**First Building Bradfield City Centre (SSD-25452459)
Additional Matters for Submissions Report**

Chris Ritchie
Director
Industry Assessments

ATTACHMENT 1

EROSION AND SEDIMENT  
CONTROL PLAN

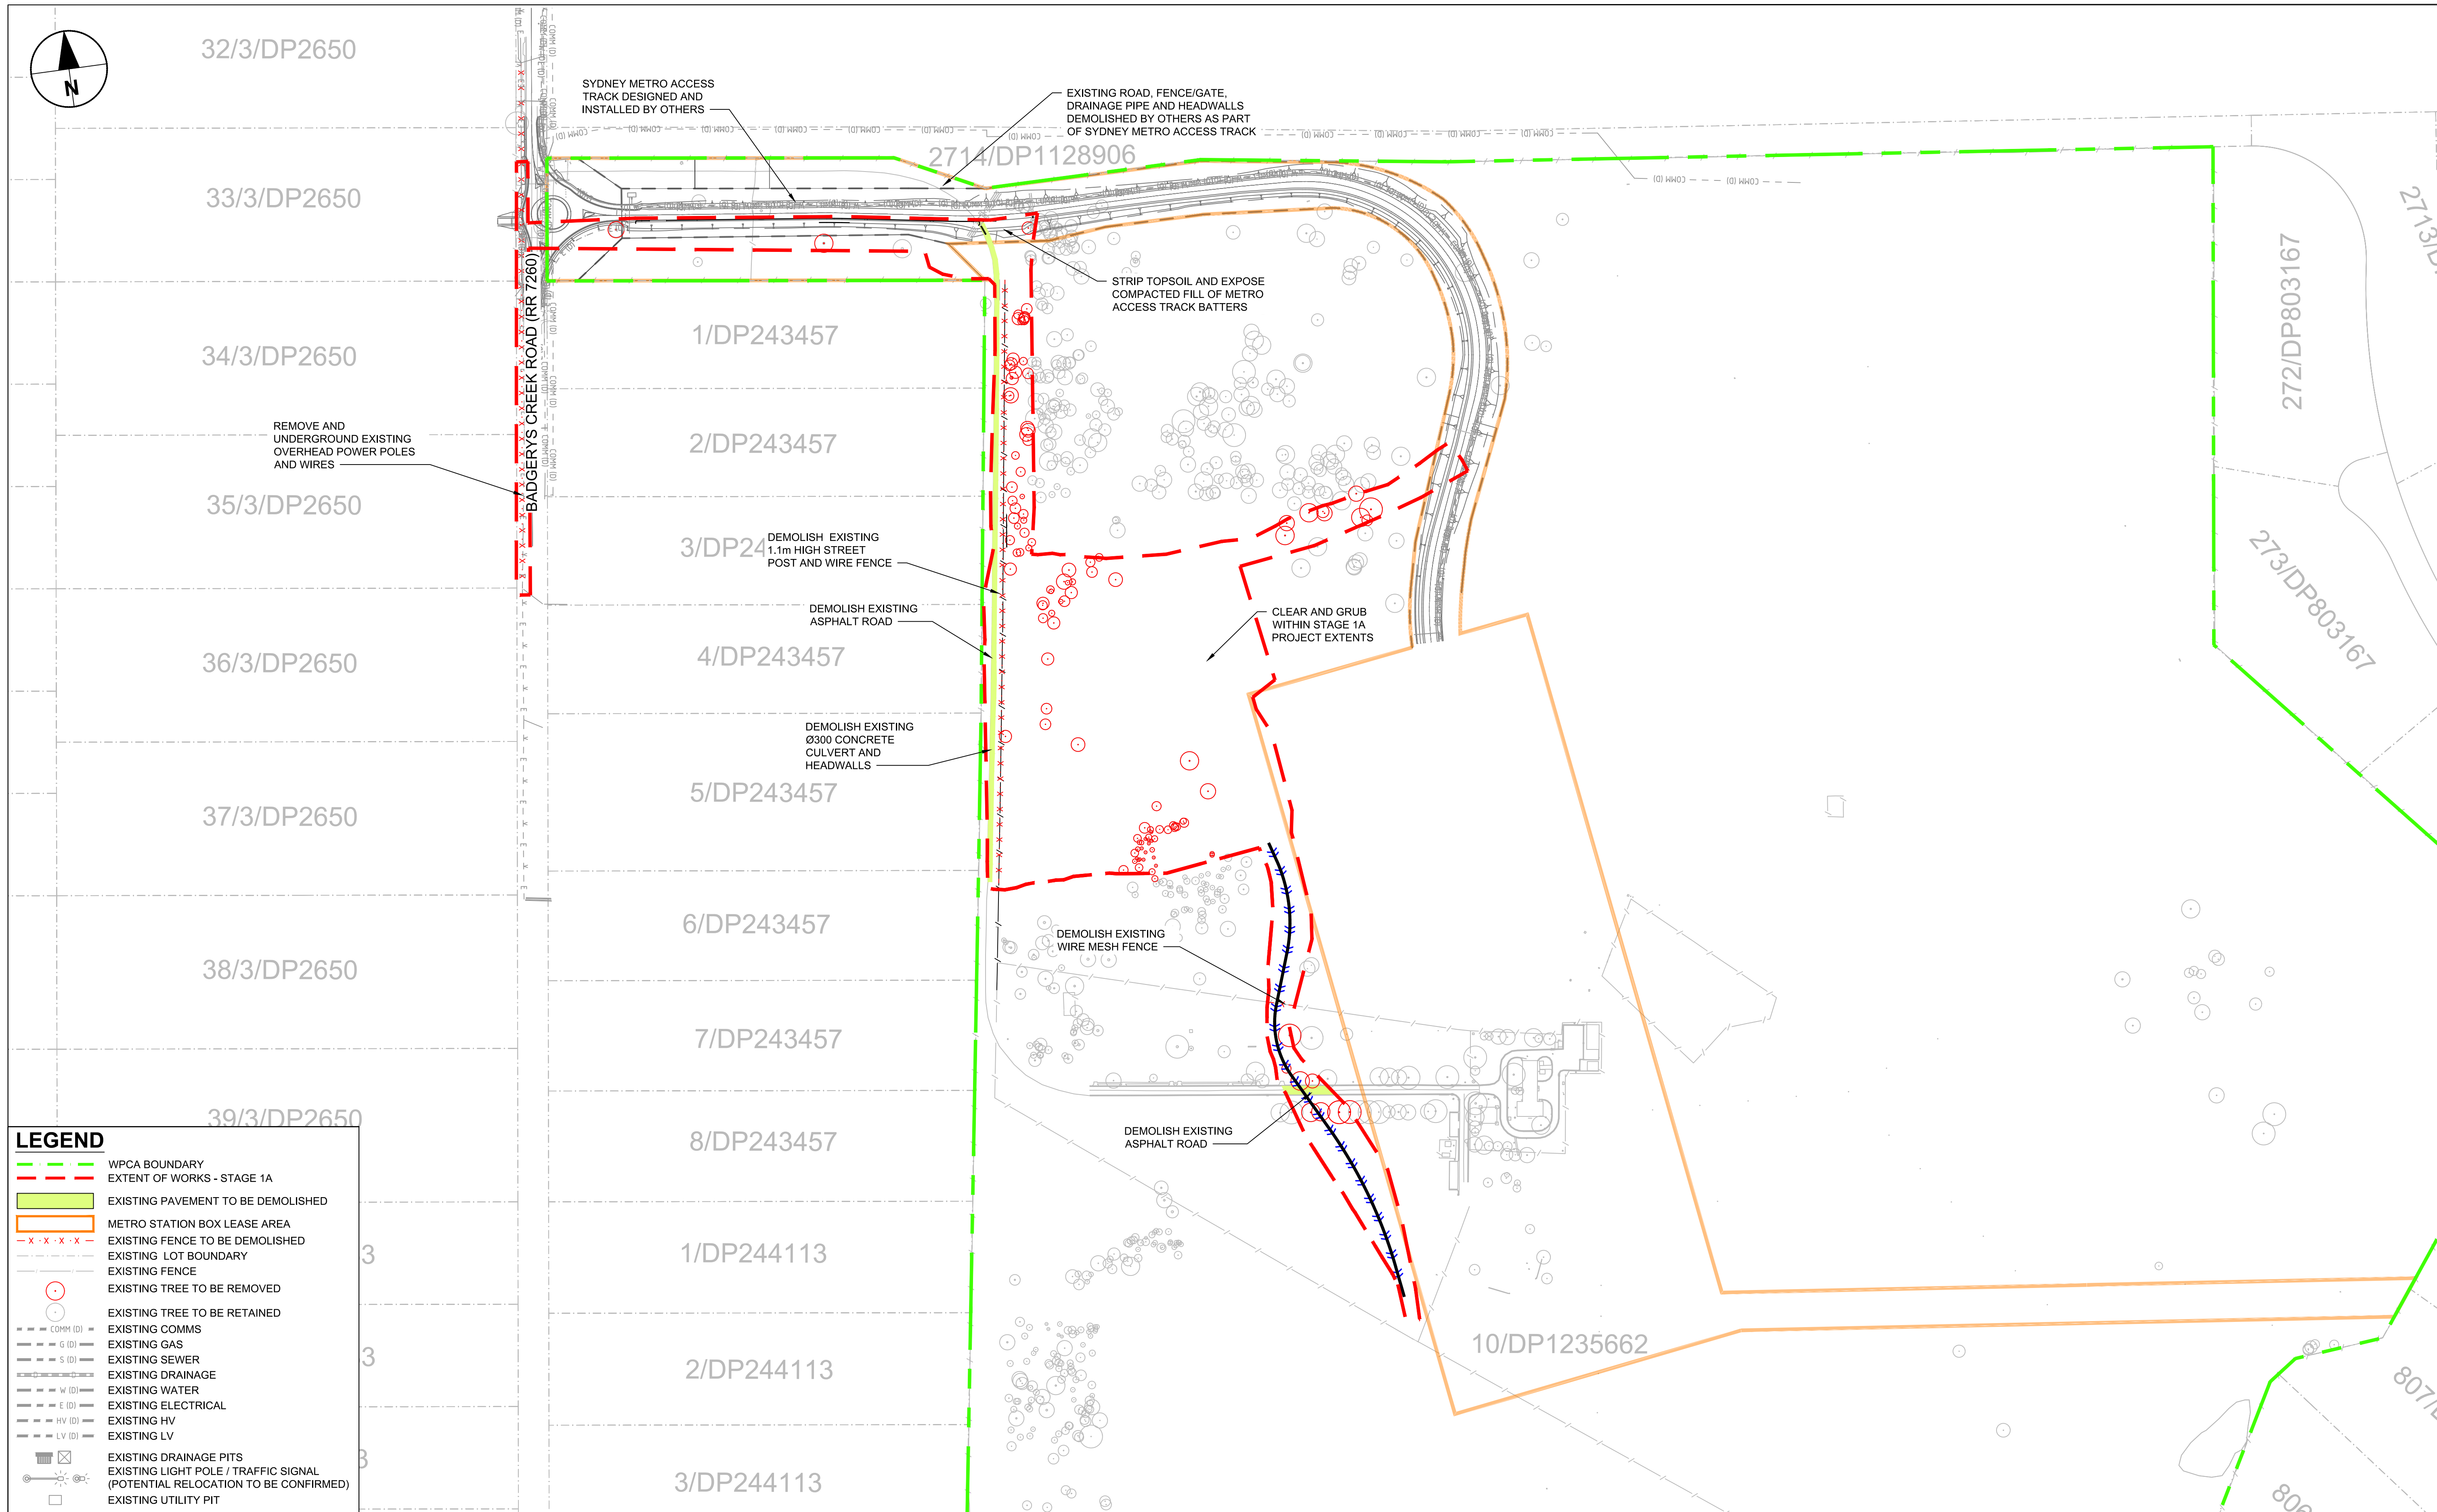
- The architectural plans do not show the temporary sediment basin and IOP which are proposed to be located east and south-east of the First Building. How will these structures integrate with the proposed landscaping for the site?
- Provide a visual impact assessment as per the SEARs requirements, including photomontages and perspectives of the development layout and design, particularly potential impacts on nearby and private receivers (including Kelvin and Church of Holy Innocents) and significant vantage in the broader public domain. While images have been provided of the development at 10 years + once the Bradfield City Centre is fully developed, photomontages at Year 0 and 5 are also required to understand the short-term visual impacts.
- On page 64 of the Design Report, the words 'Winter Solstice 21 December' may be a typo.

TURNING PATH PLAN -  
12.5m HRV

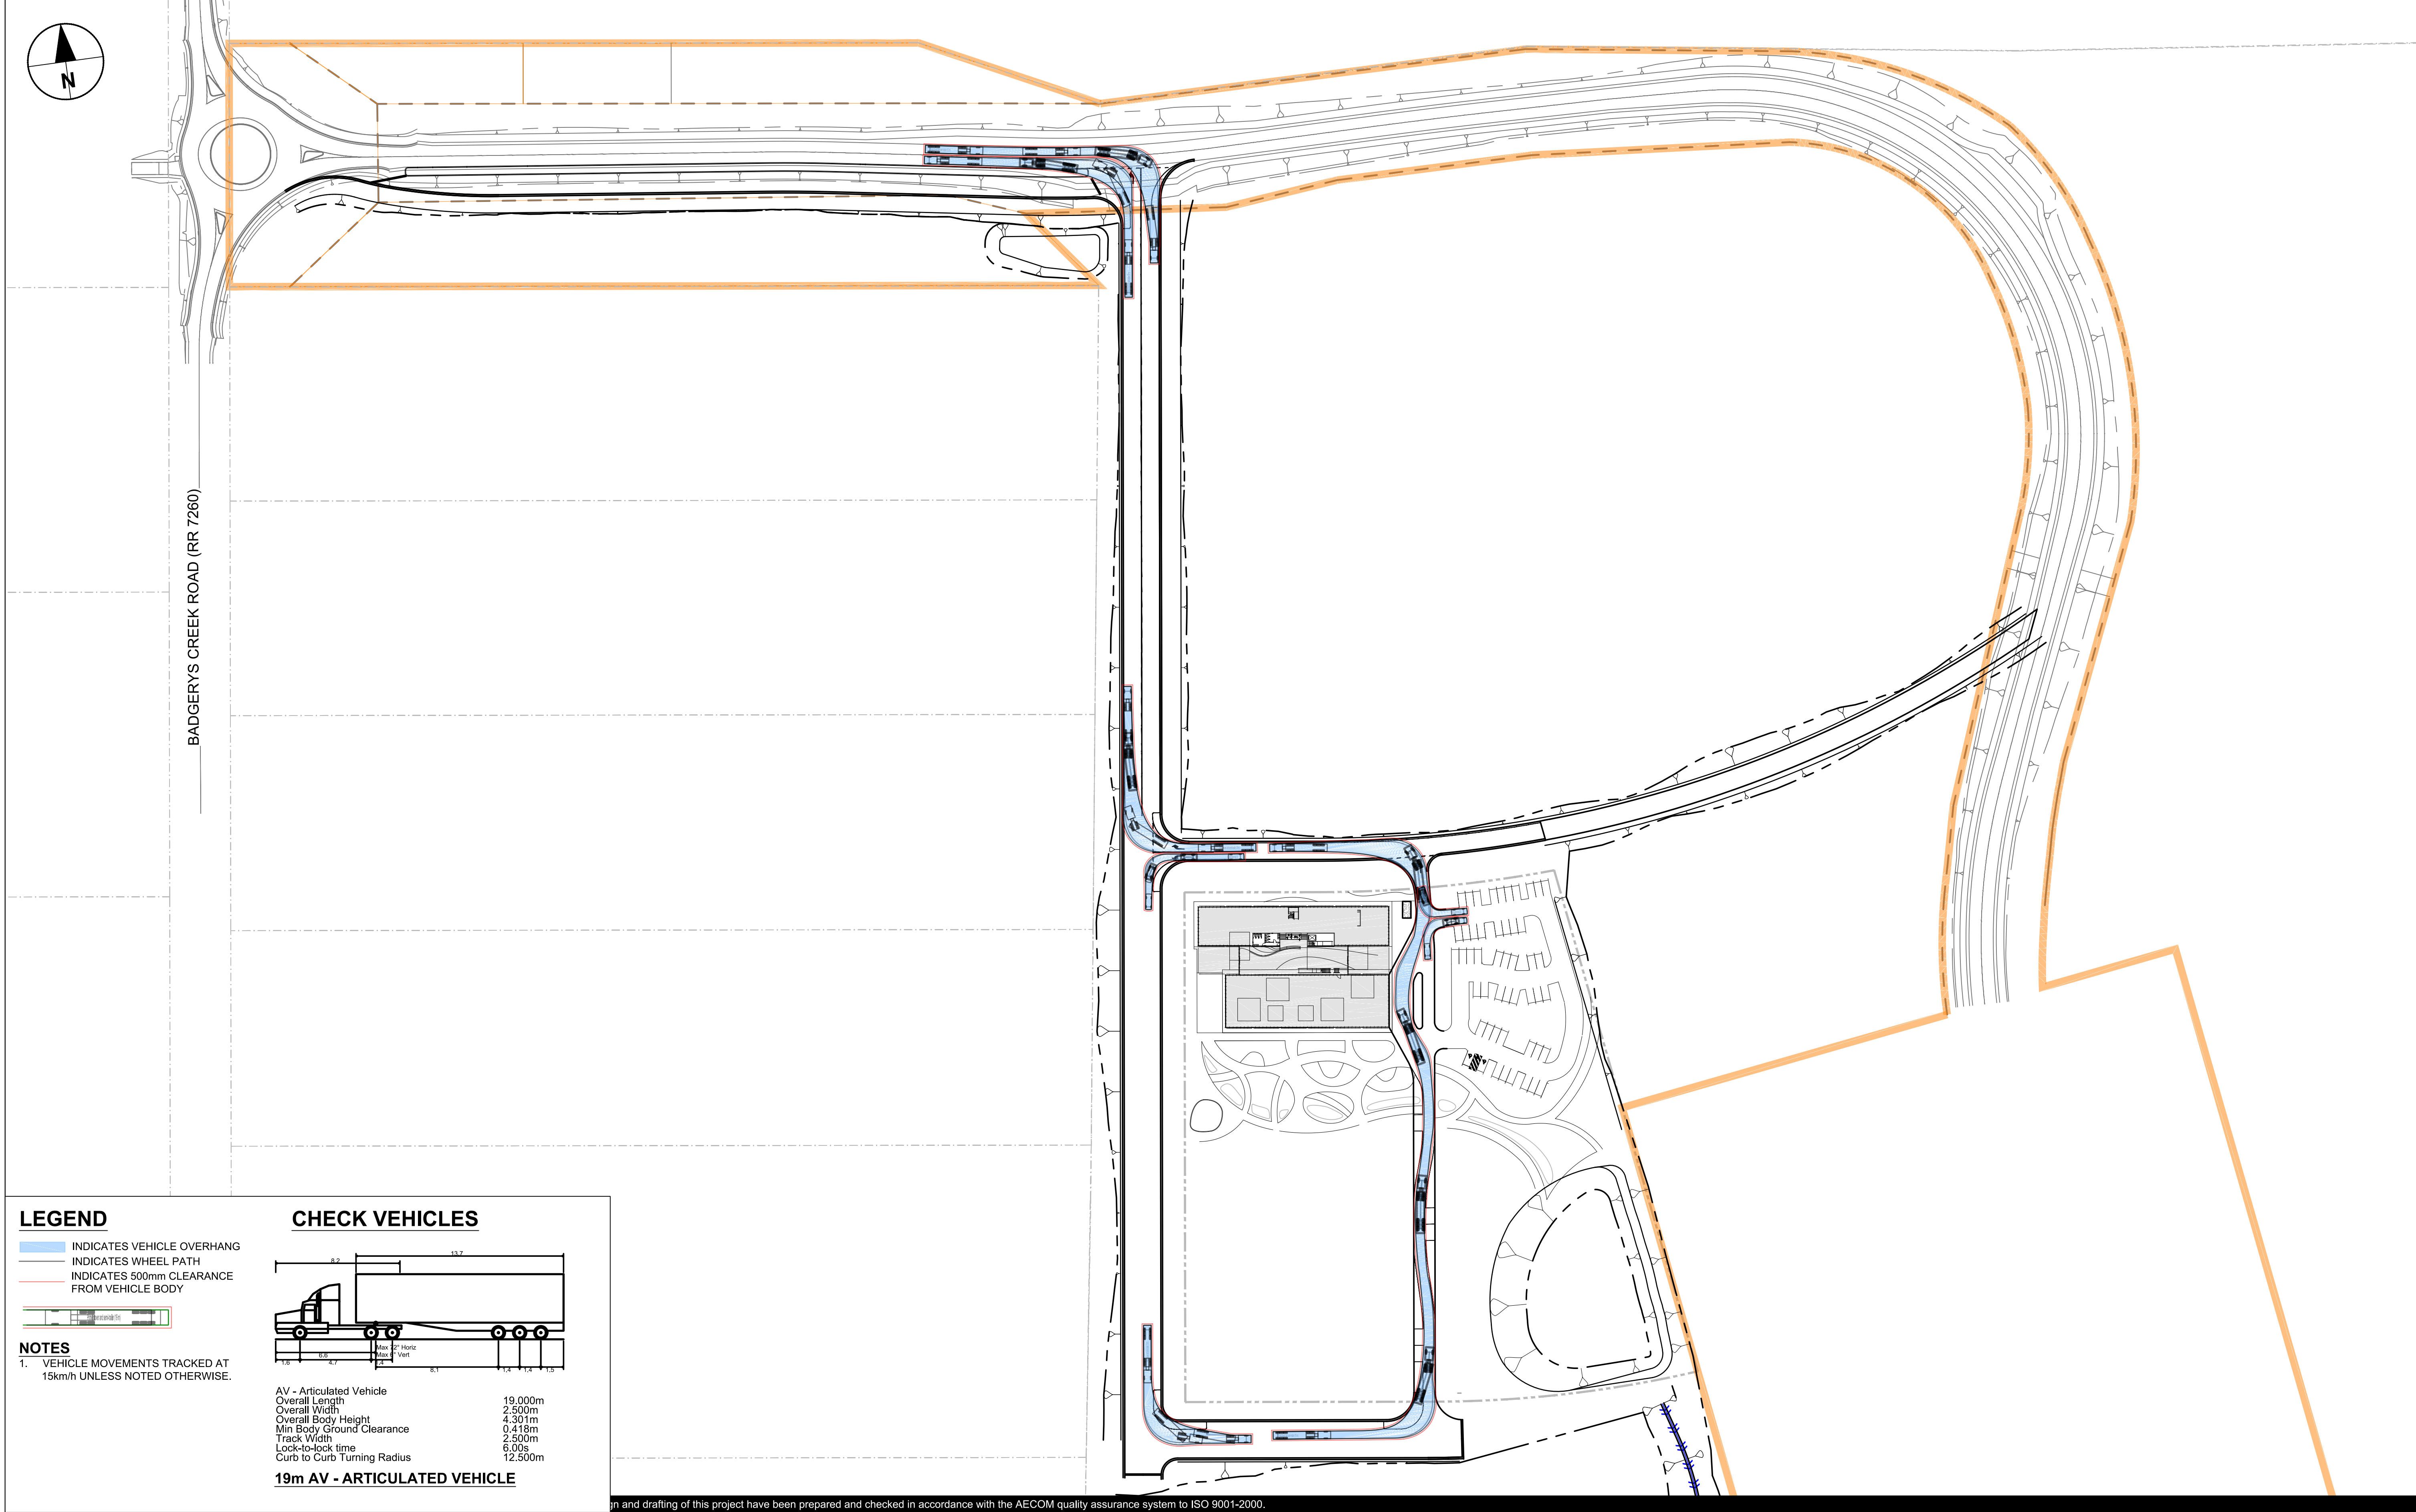
- The civil plans include swept path diagrams of the largest truck accessing the site along the service road. Where is the designated heavy vehicle parking on the service road and how are heavy vehicles loaded and unloaded? Can heavy vehicles reverse into the loading bay?
